Springwell Solar Farm, October 2024

Springwell Solar Farm Section 55 Acceptance of Applications Checklist

DRAWING TITLE:  
**ILLUSTRATIVE LAYOUT PLANS &  
 SECTIONS  
 SHEET 11 OF 16**

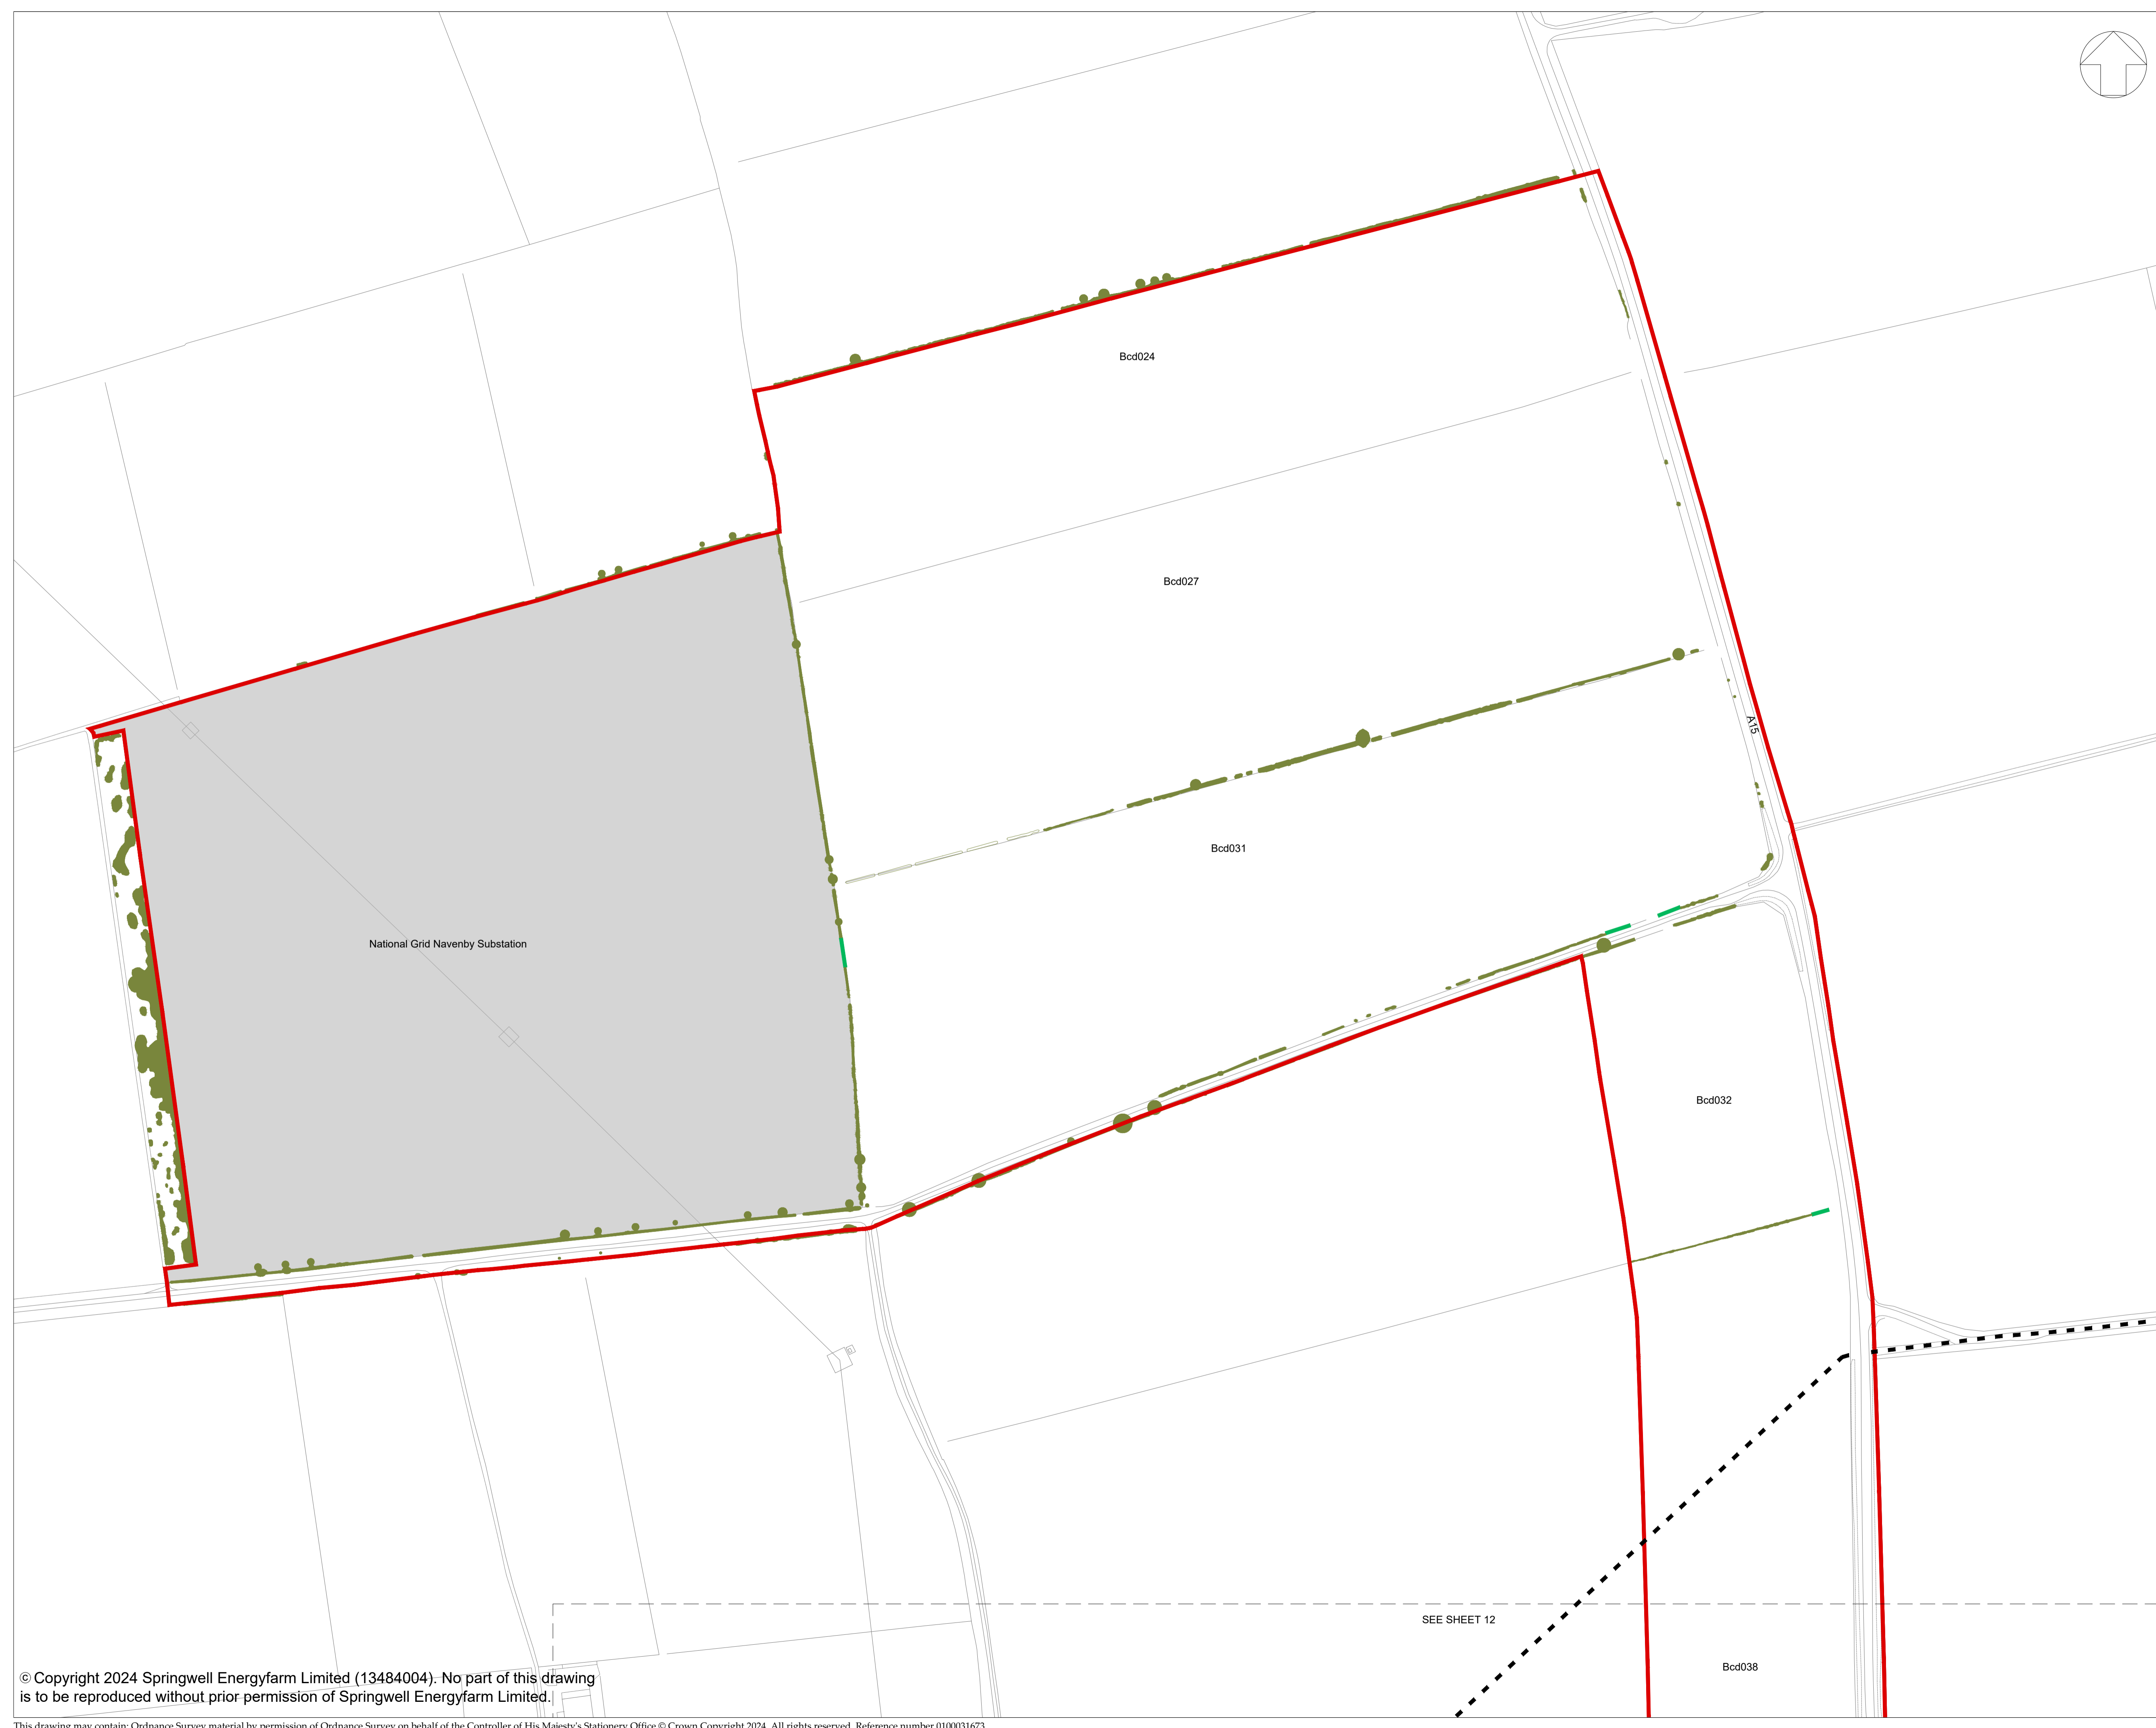
There is no key for the Proposed Substation or Battery Energy Storage System. The Applicant is advised to review/amend accordingly.

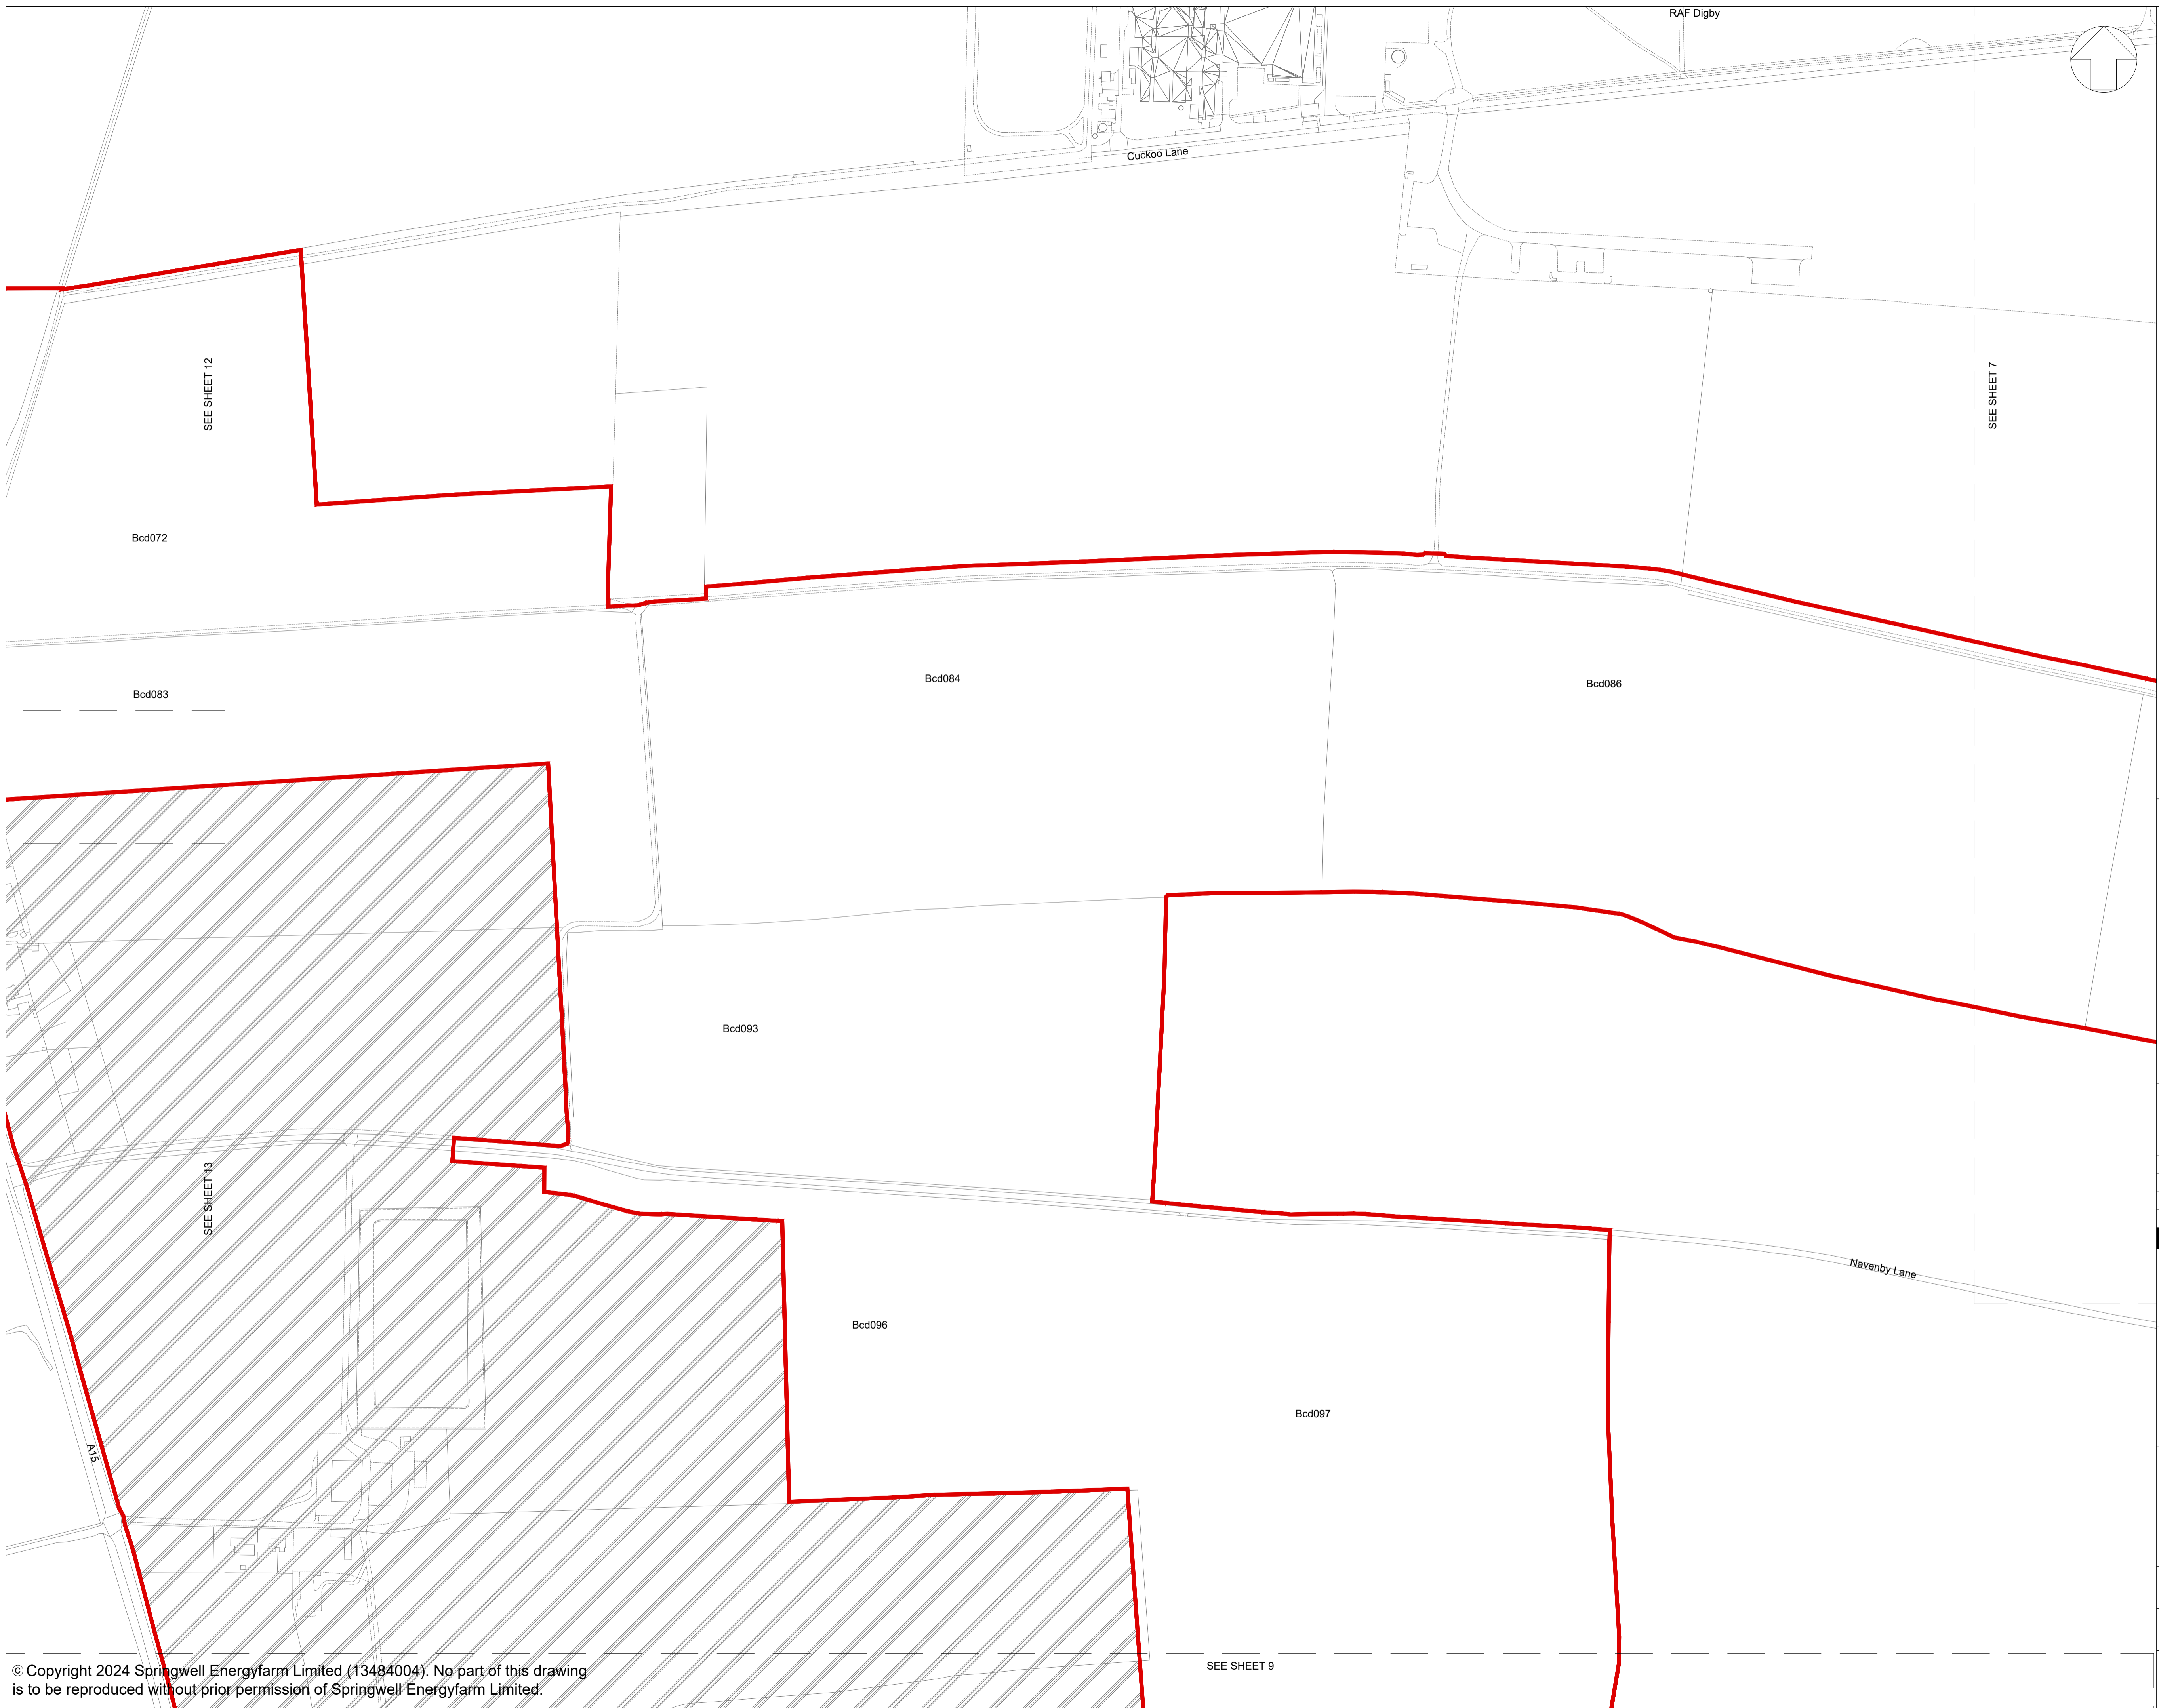
It is unclear if the inset showing B1191 (Heath Road) on sheet 7 of 15 is to the same scale as the rest of this sheet. The Applicant is advised to review/amend accordingly.
